From: Andrew Fuller [REDACTED]
Sent: 05 March 2018 12:31
To: Anita Gardner
Cc: Juan Baeza; Martyn White; Nick Field; mv rowan; AFA
Subject: Re: Planning Consultation on: AB/149/17/L

**Listed Building Consent for Alterations, Extension or Demolition of a Listed Building
APPLICATION AB/149/17/L**

Site Address: 44 Tarrant Street Arundel BN18 9DN

Description of Works: Listed building consent for internal alterations & renovations

*Bryceson Shaw Item "Kitchen" and drwg 2176/01/03

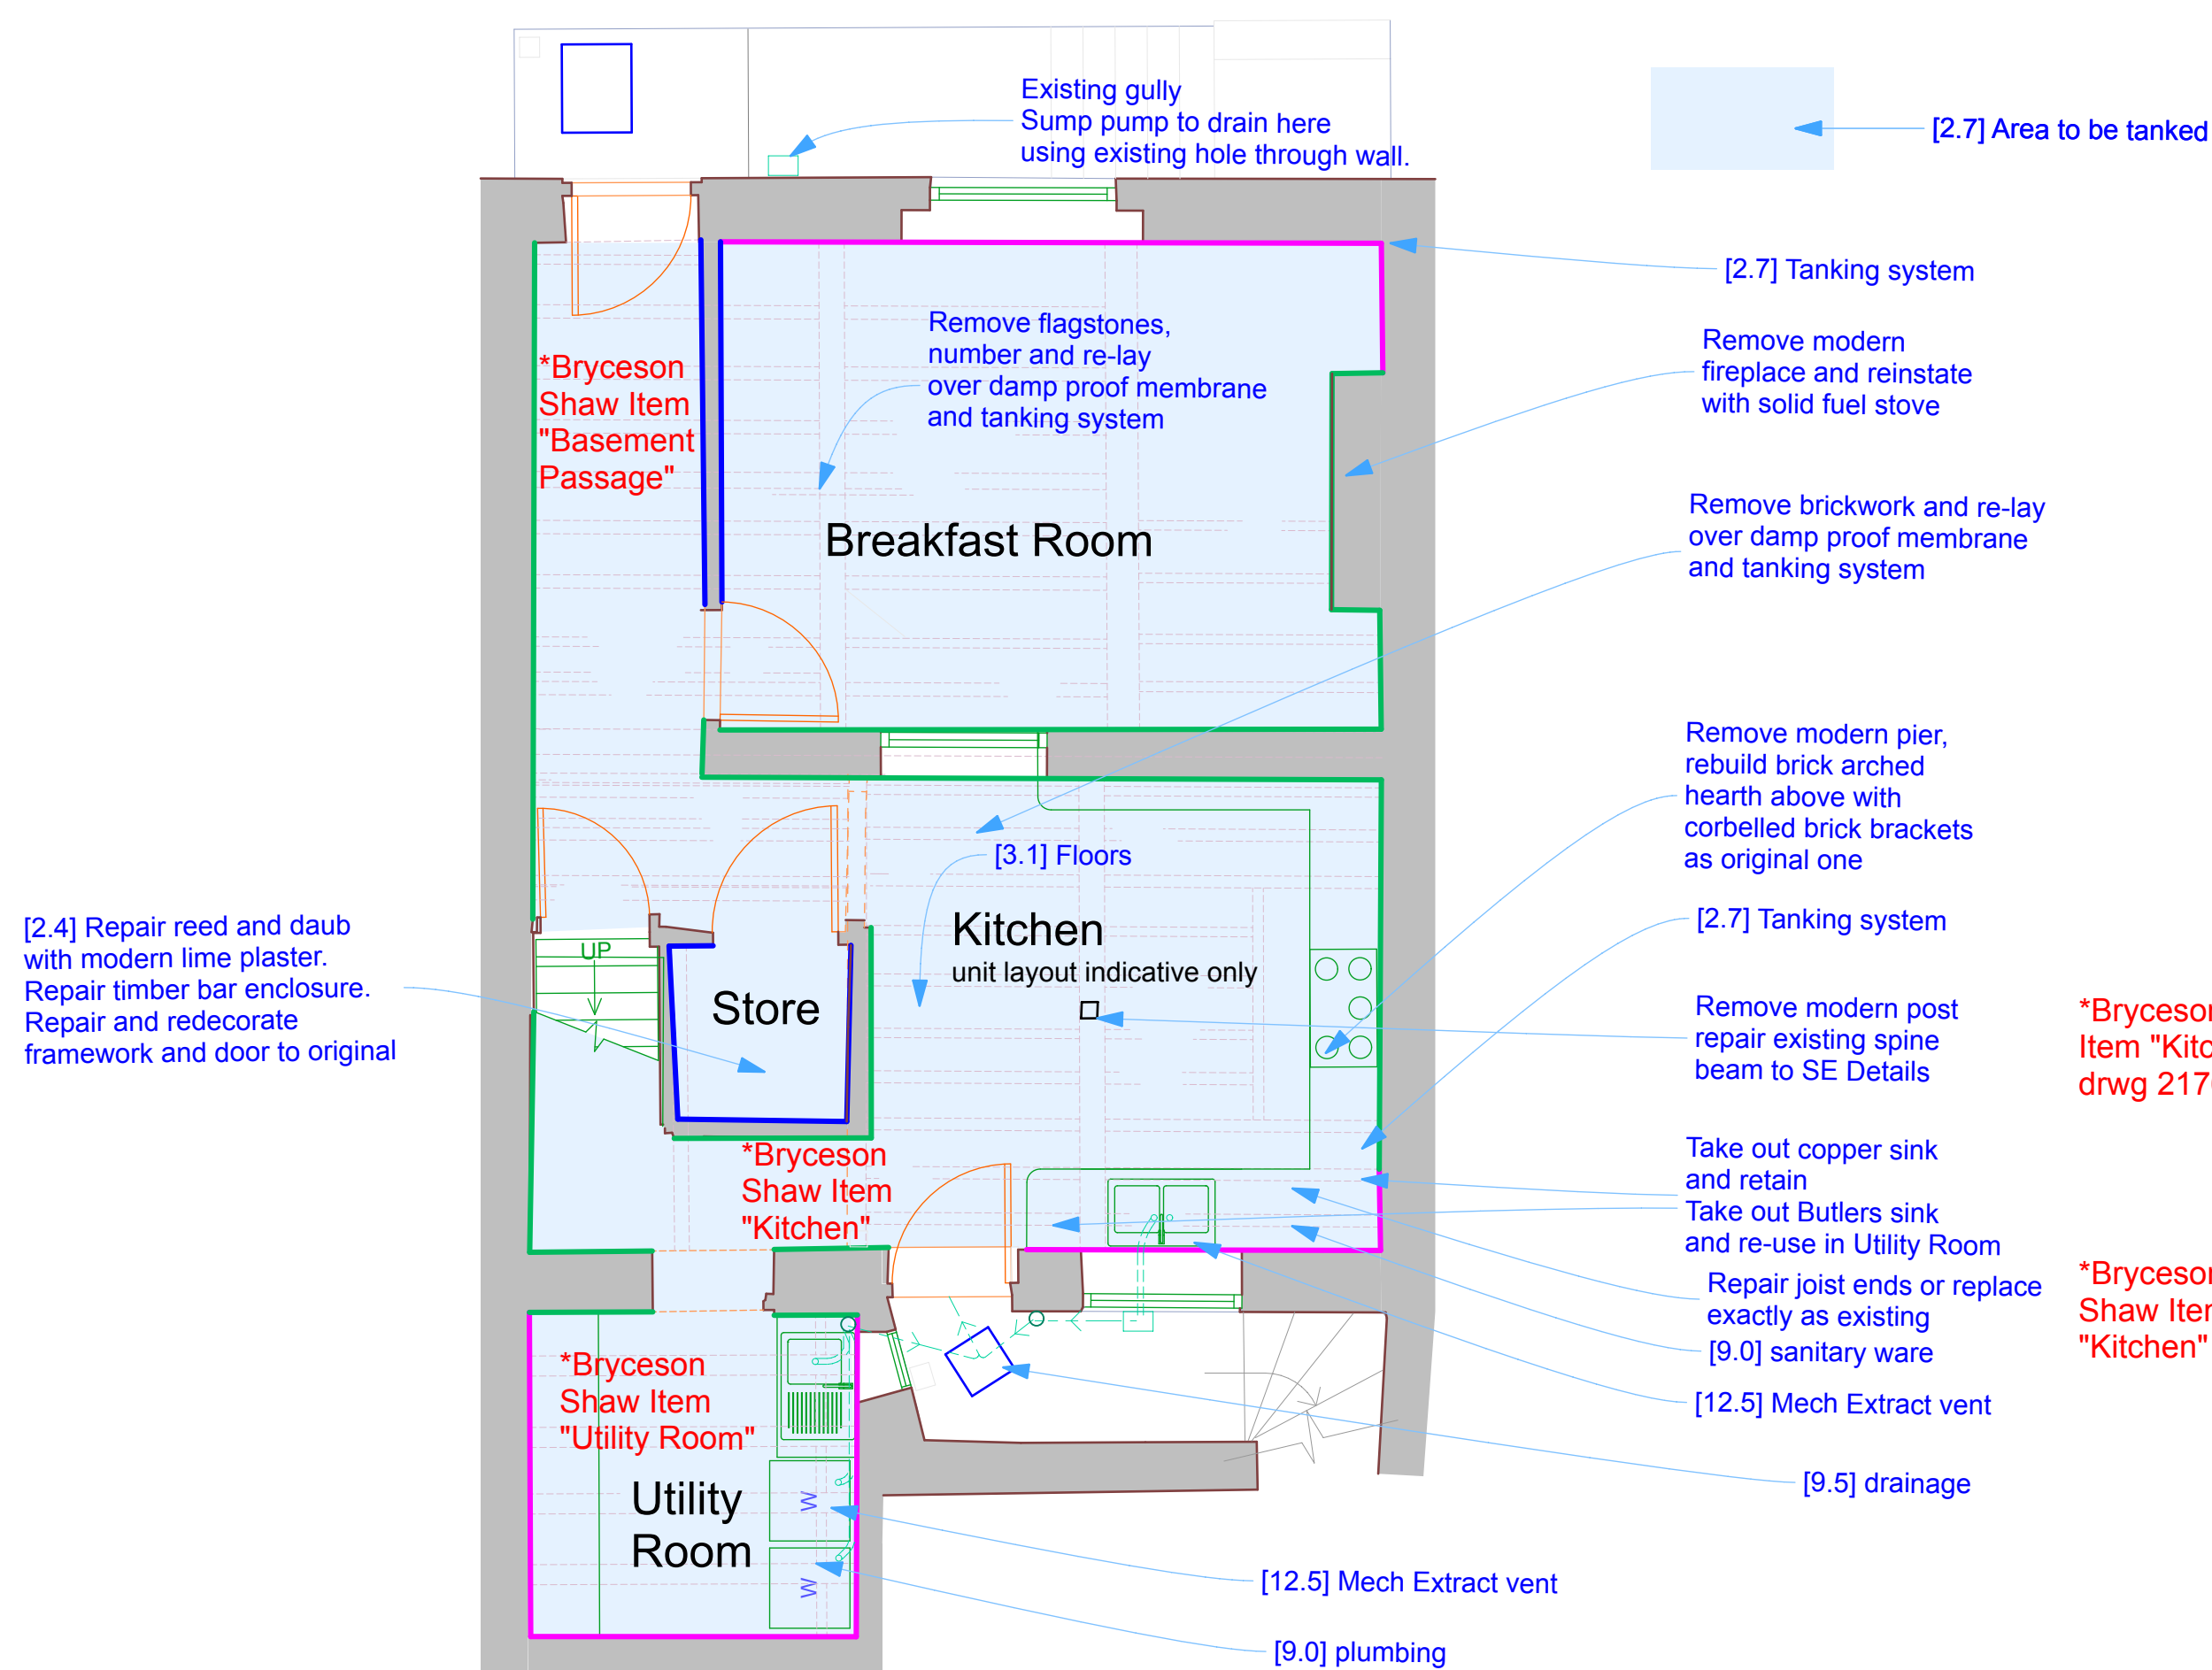
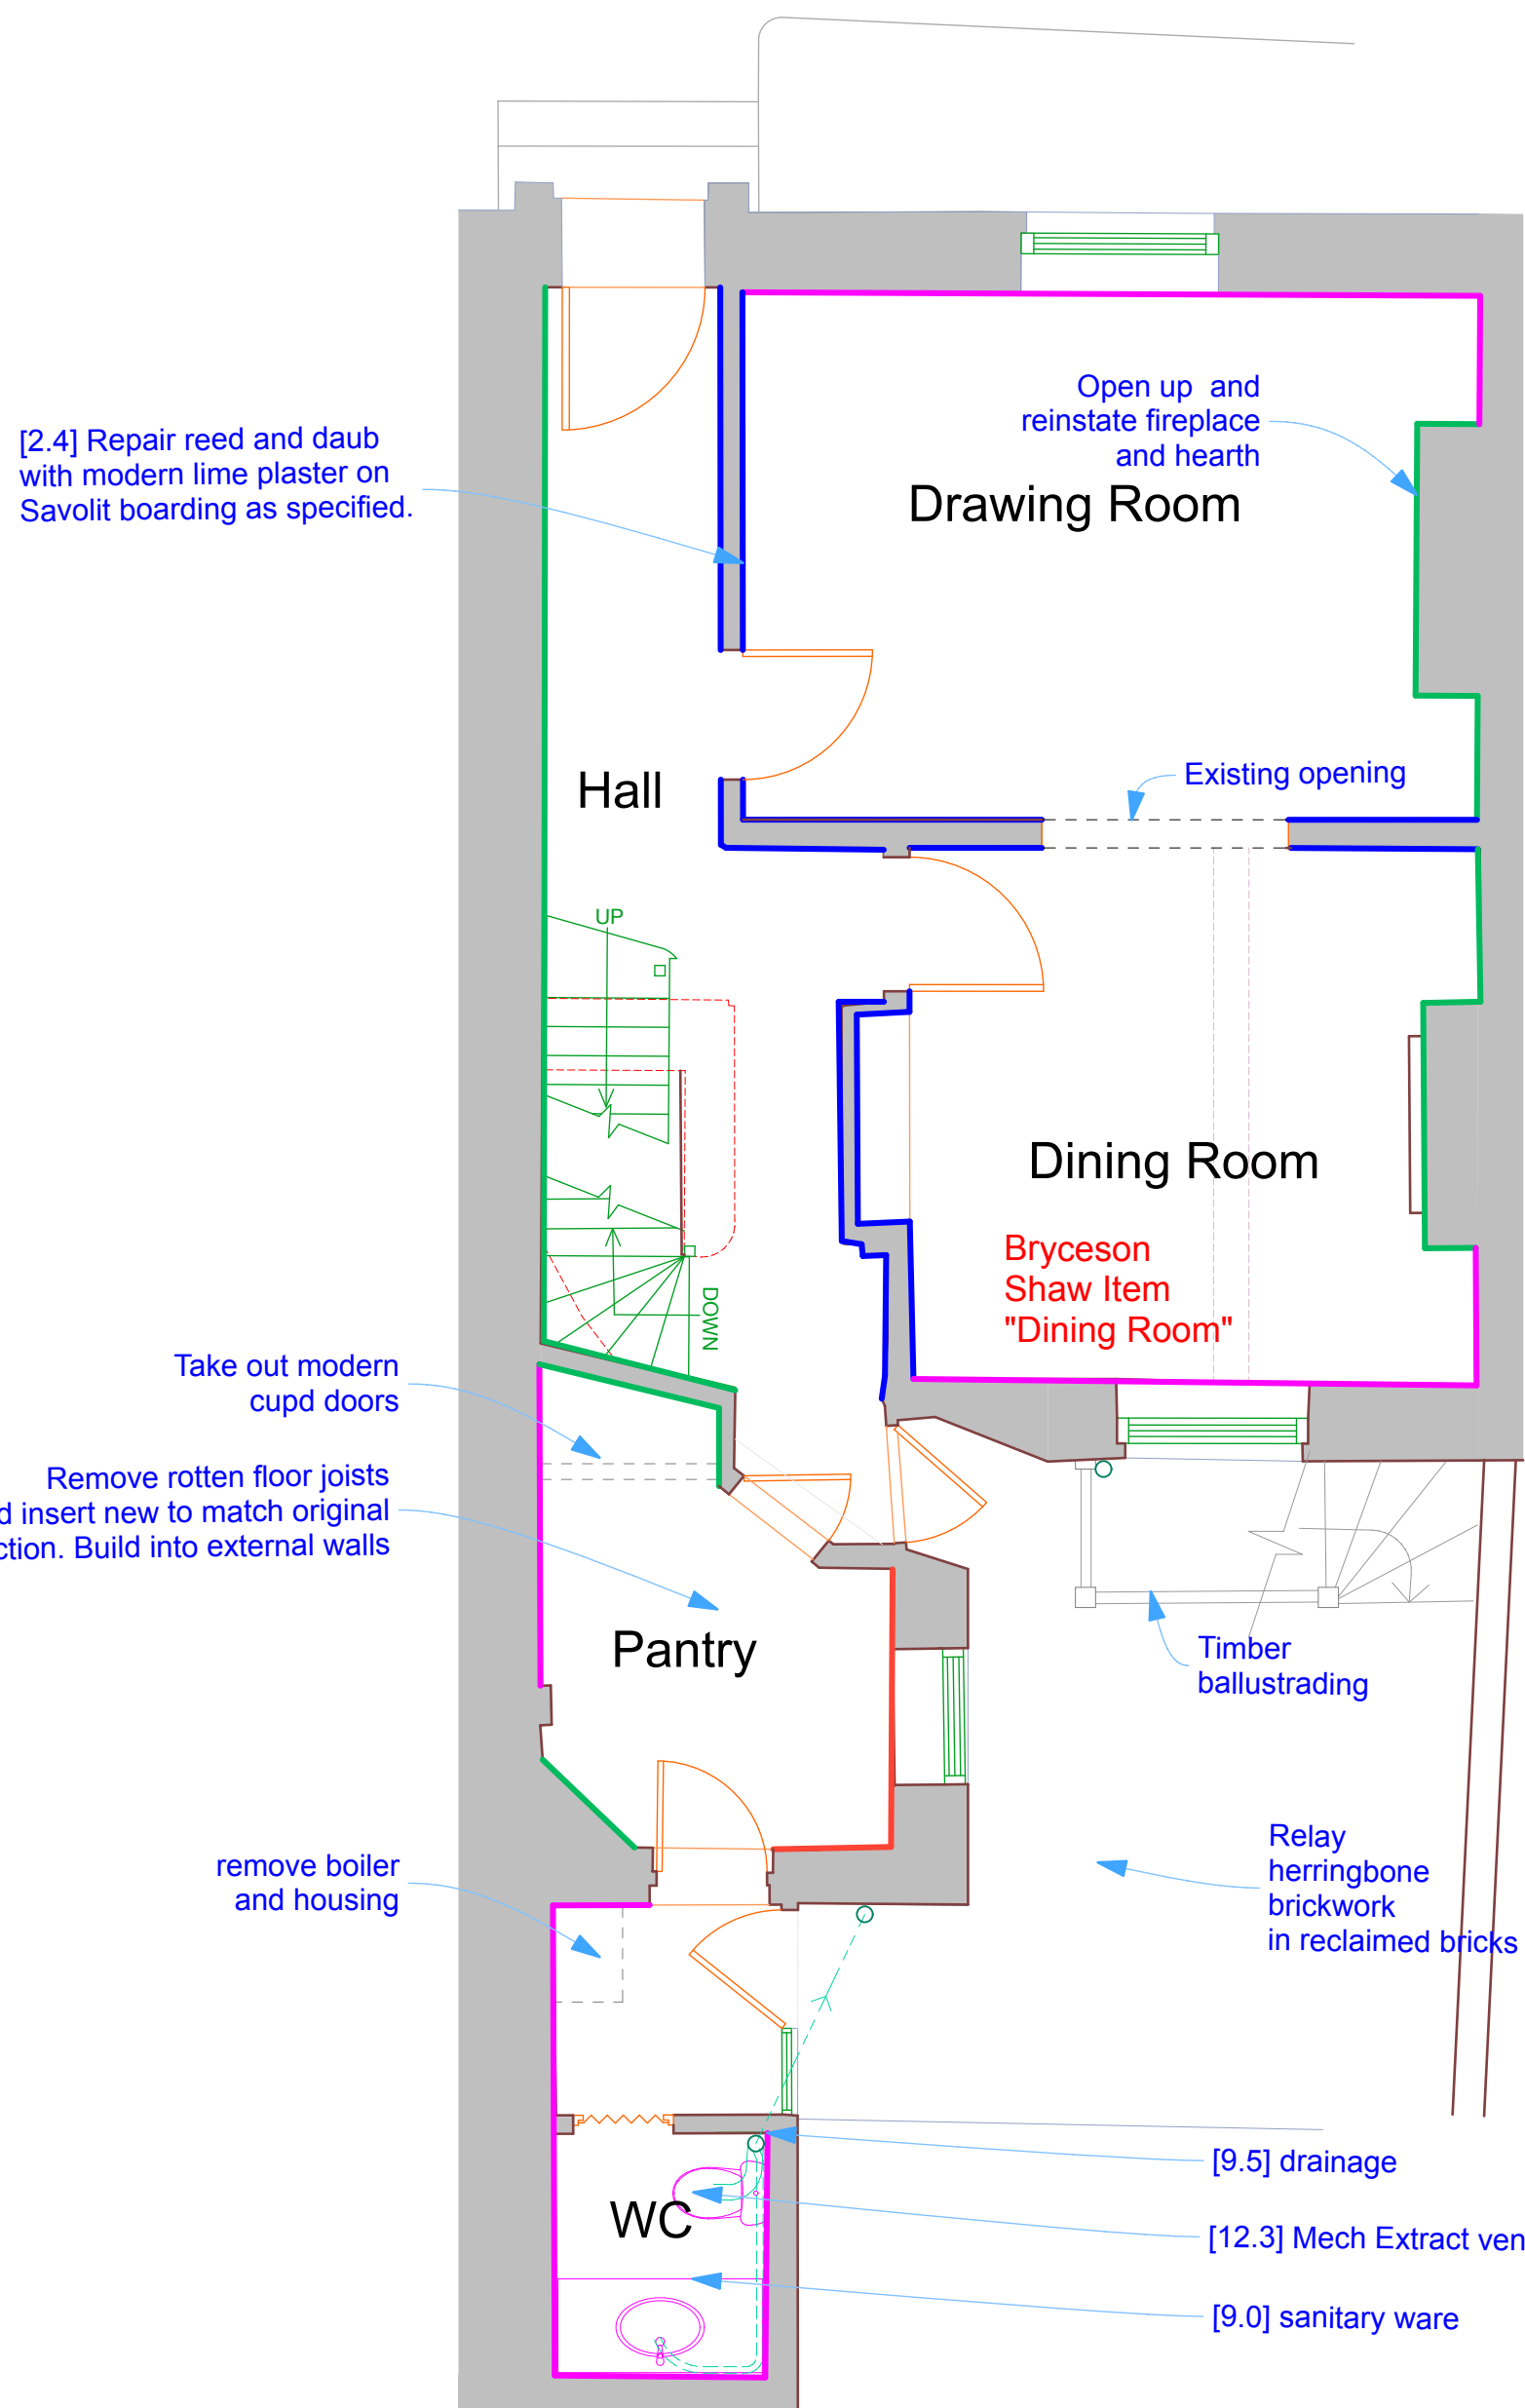
- It is unclear as to proposed location of structural drawing 'Proposed Repair' Bryceson Shaw Associates. This detail is not marked on any plans.
- Unclear 'SE Drawing & Report' referred to under 'Kitchen Proposed' – (This is apparently spine beam repair)

Annotation (by SE drawing no) of plans, even though these items have been discussed on site, is not an acceptable reason for recommending refusal. We will highlight this opinion in any upcoming appeal that occurs.
